NOTIFICATION OF EXHIBITION – SIGMA PHARMACEUTICAL WAREHOUSE AND DISTRIBUTION CENTRE (SSD 7719)

I refer to the Notice of Exhibition dated 14 November 2016 inviting Council comment on the development application for the Sigma Pharmaceutical Warehouse and Distribution Facility, located at Lot 12 in DP 1178389, 2a Aldington Road, Kemps Creek in the Penrith local government area.

Drawing Name:
Landscape Site Plan

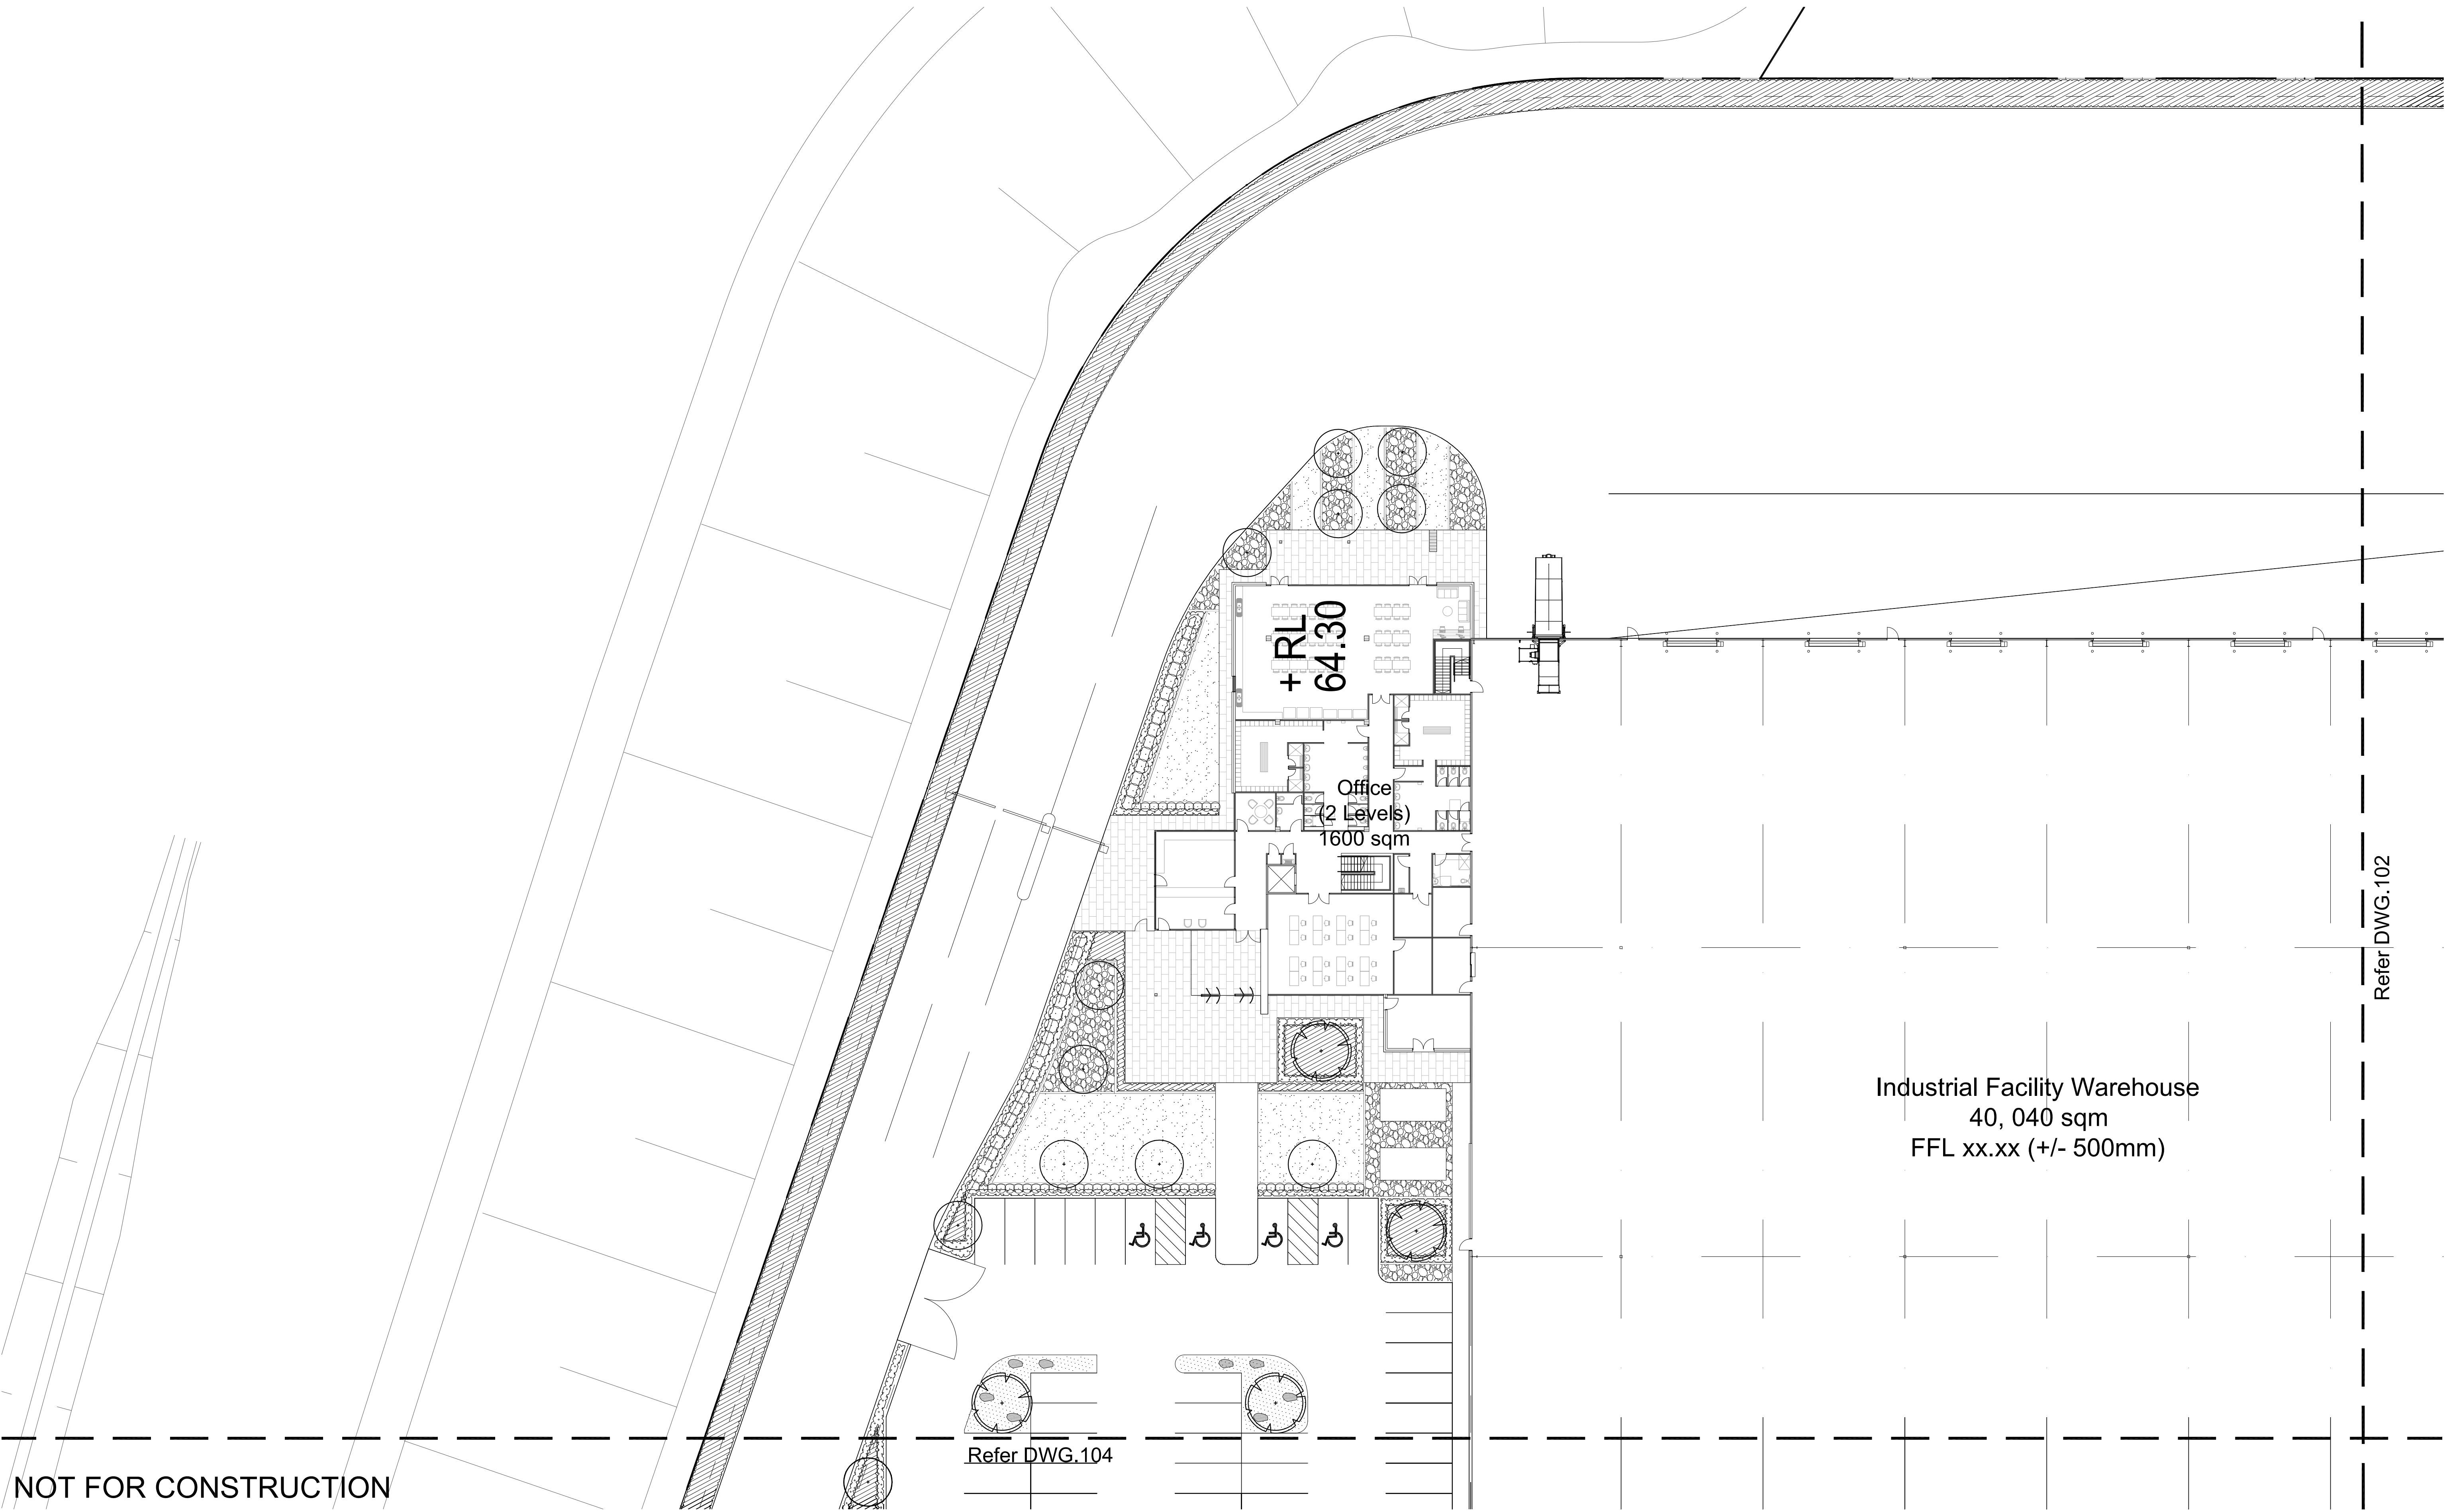
The area of ballast located at the north-eastern corner of the site presents poorly to the street (Estate Road 01). To avoid heat effects and poor streetscape presentation, this area should be landscaped with a range of native trees, shrubs and grasses. The use of ballast in such a large volume on a prominent corner of the site is not supported and is contrary to the Council's DCP 2014 in particular Chapter D4 Industrial Development.

The car parking hard stand area is not provided with sufficient shade throwing canopy trees. Additional planting should be provided to the most western car parking row.

Native canopy trees such as spotted or grey gums are to be provided along the eastern and southern elevations of the warehouse with frontage to Estate Roads 04 and 01.

A landscaped buffer should be provided along the front of the most eastern car parking row providing a landscaped buffer to the building and pedestrian way. A landscaped buffer should be provided between the central car parking rows.

It is noted that tree and shrub species locations are not identified on the submitted landscape plans.

02 South Elevation
WAREHOUSE 3A

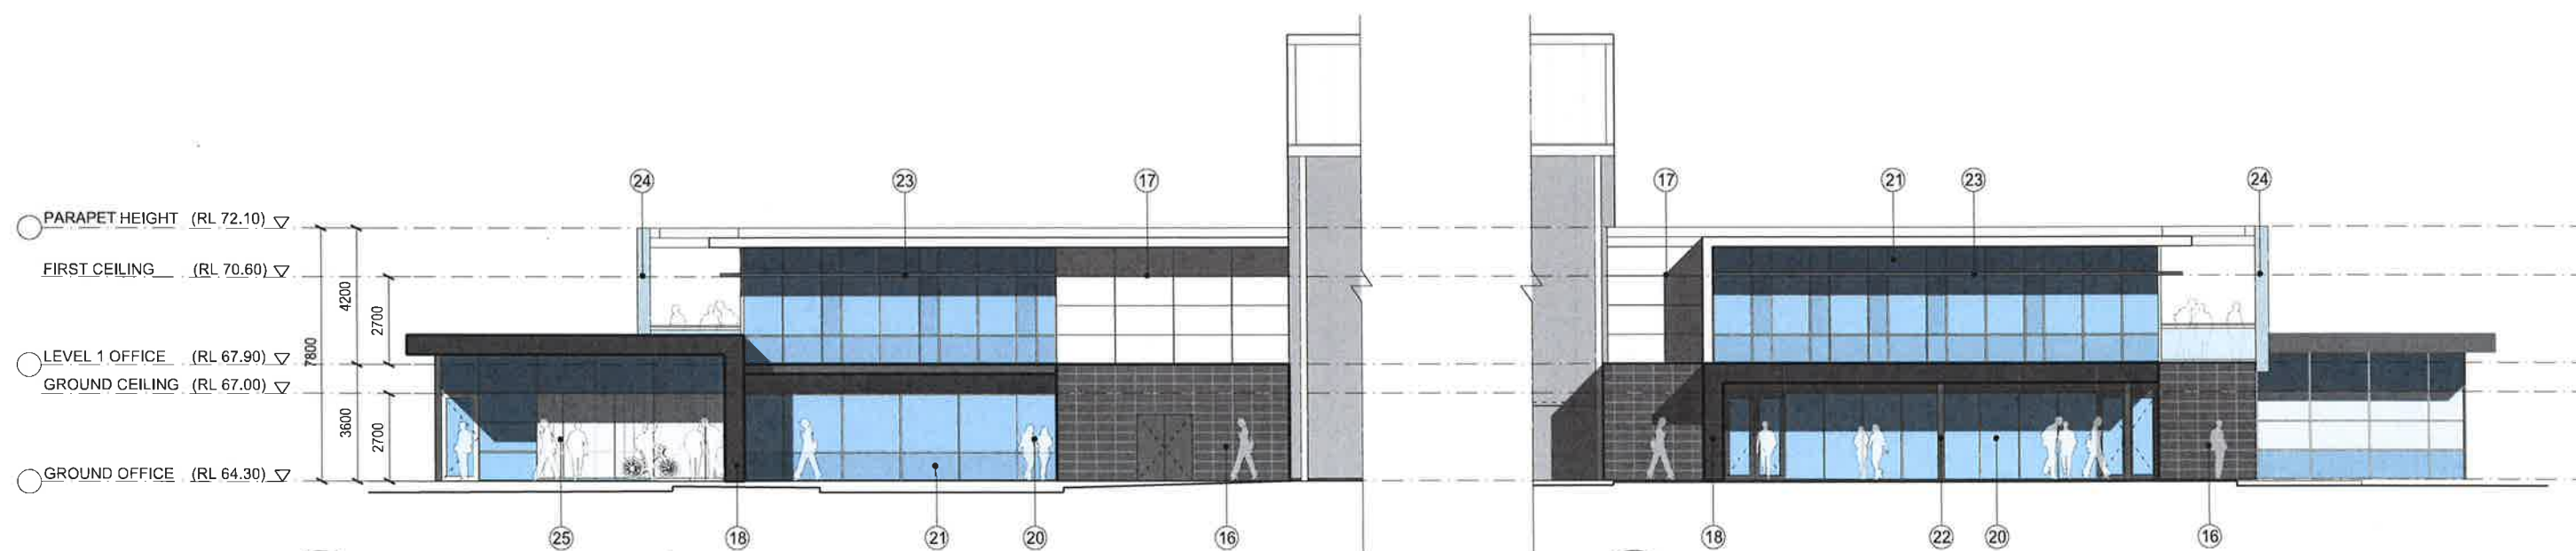
In accordance with the Penrith DCP 2014, the development should address the street frontages. It is preferred that main entryways and landscaped car parking fronts the public domain and street elevations providing articulated and activated elevations. In this respect, it is noted that the location of the office and primary entry point of the building is to the rear of the site and large expanses of unarticulated panelling present to Estate Roads 04 and 01.

Large expanses of wall or building mass shall be broken up with the use of additional architectural treatments and significant and sustainable landscaping elements. The use of highly visible colours such as yellow and purple should be avoided on the northern and western elevations due to the potential impact on views from the surrounding rural areas.

S2 SIGN 2
Corporate Illuminated Sign
7000w x 2500h

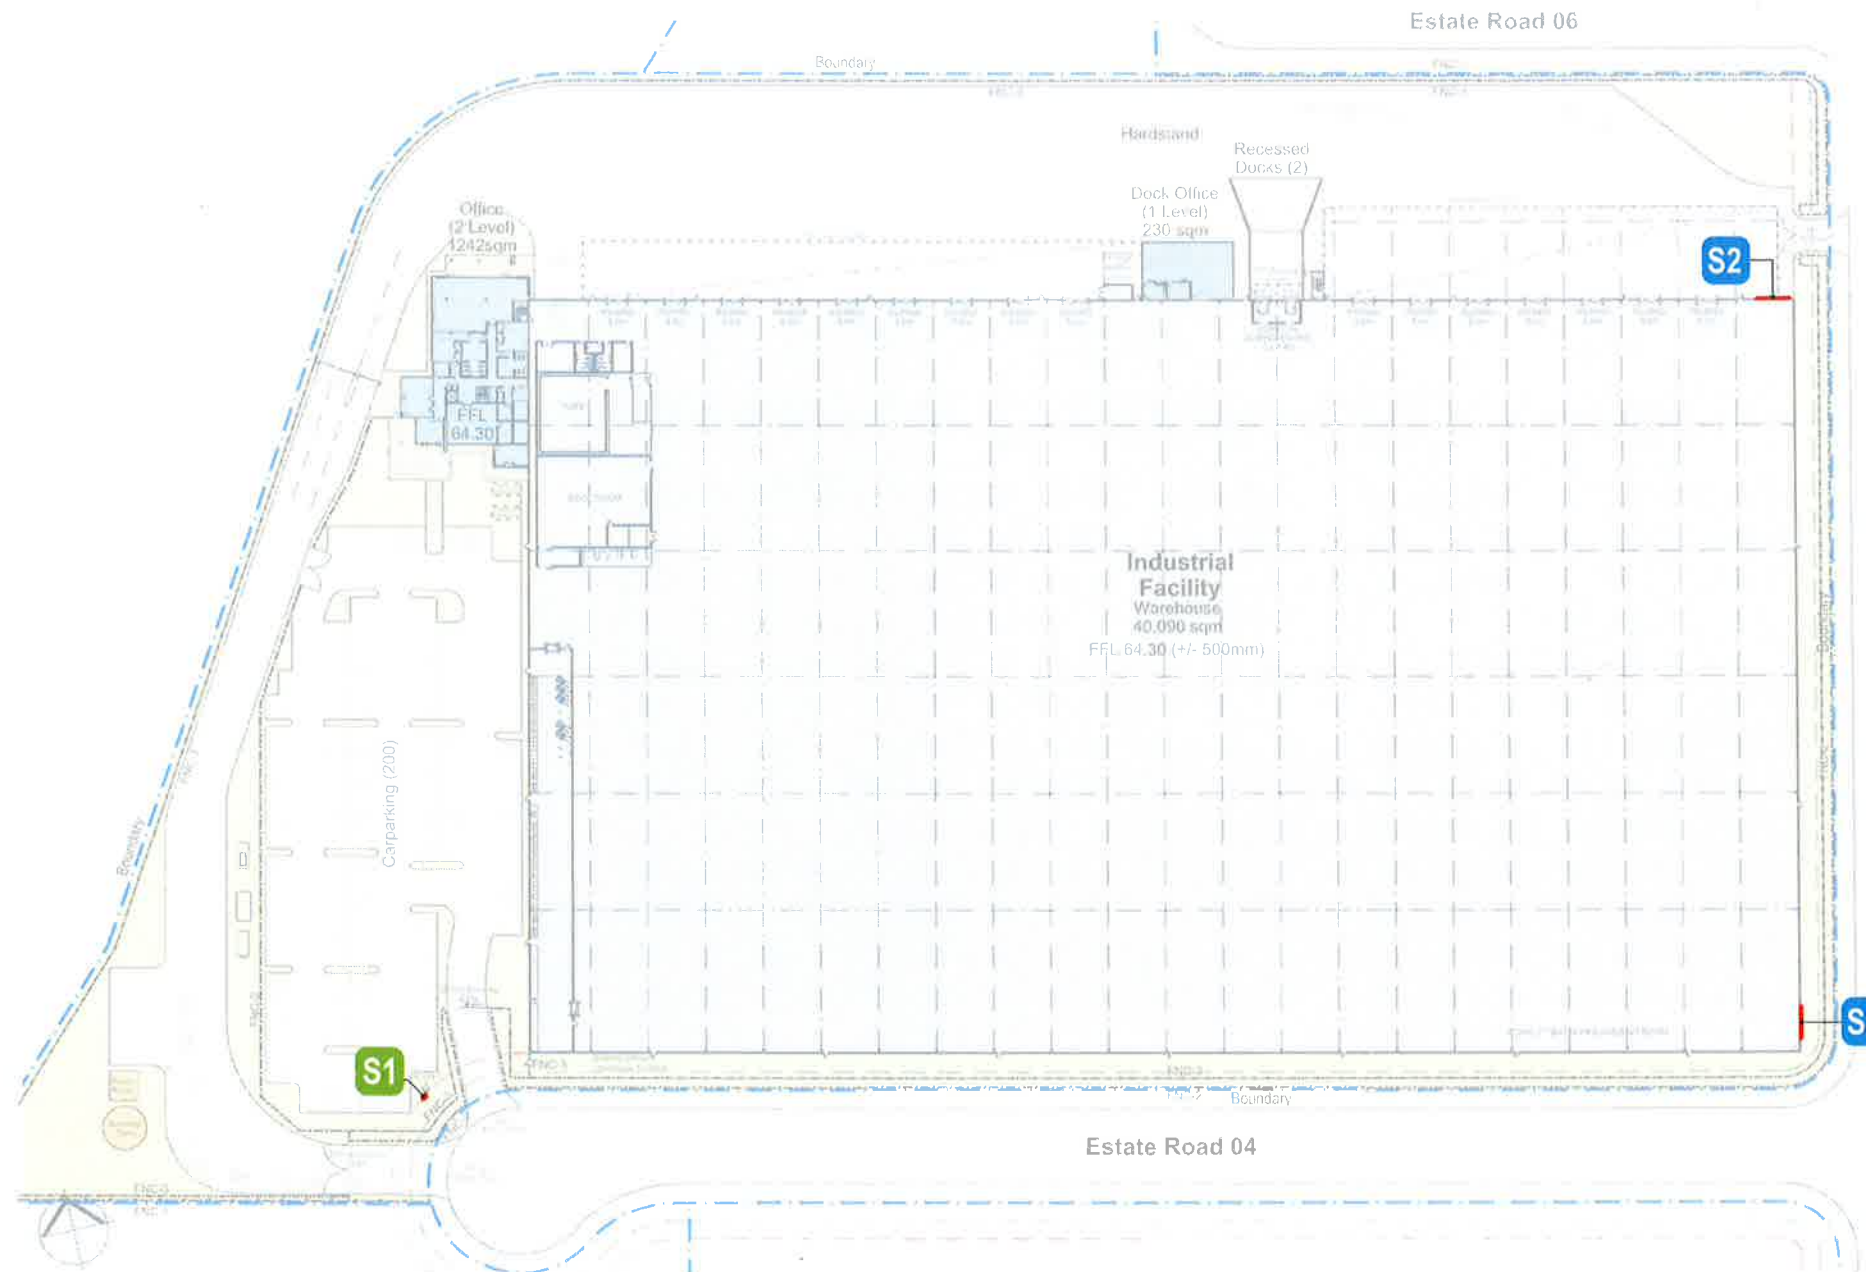
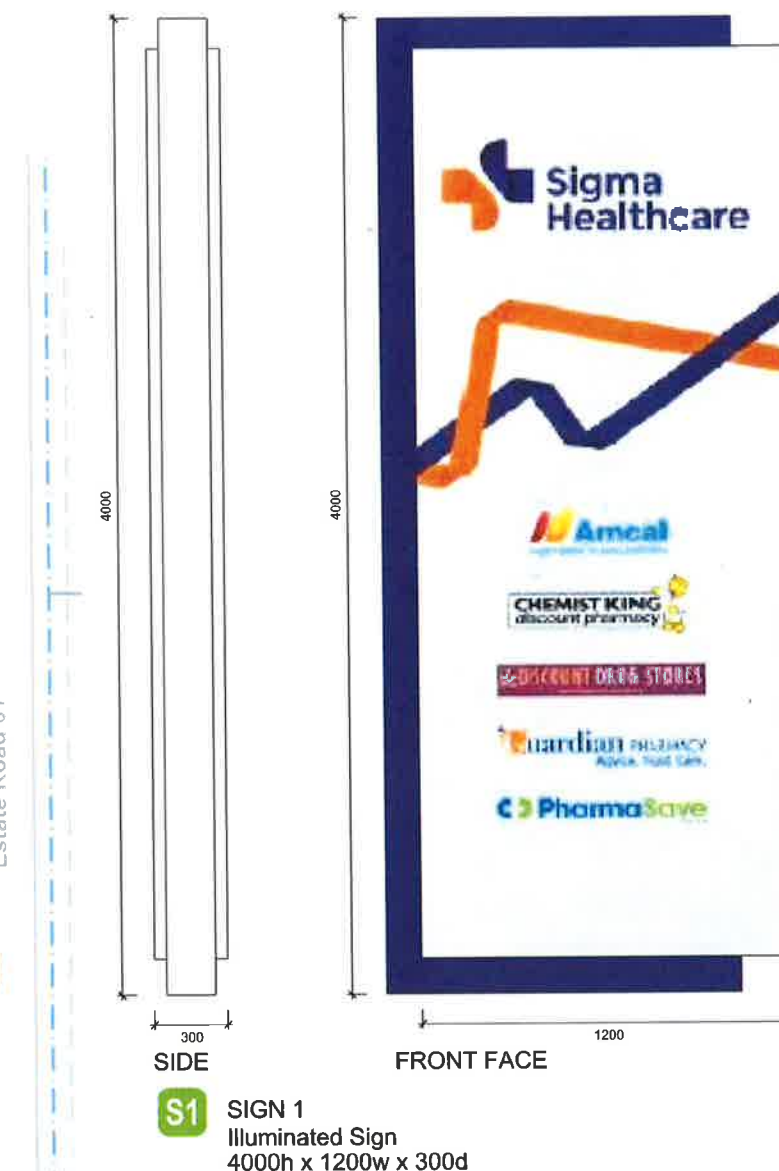
No details have been provided with regard to the location of proposed signage however it is noted that 1 x 4m high internally illuminated pylon sign and 2 x wayfinding site signs are proposed.

Internally illuminated signage shall be positioned such that nuisance glare is avoided.
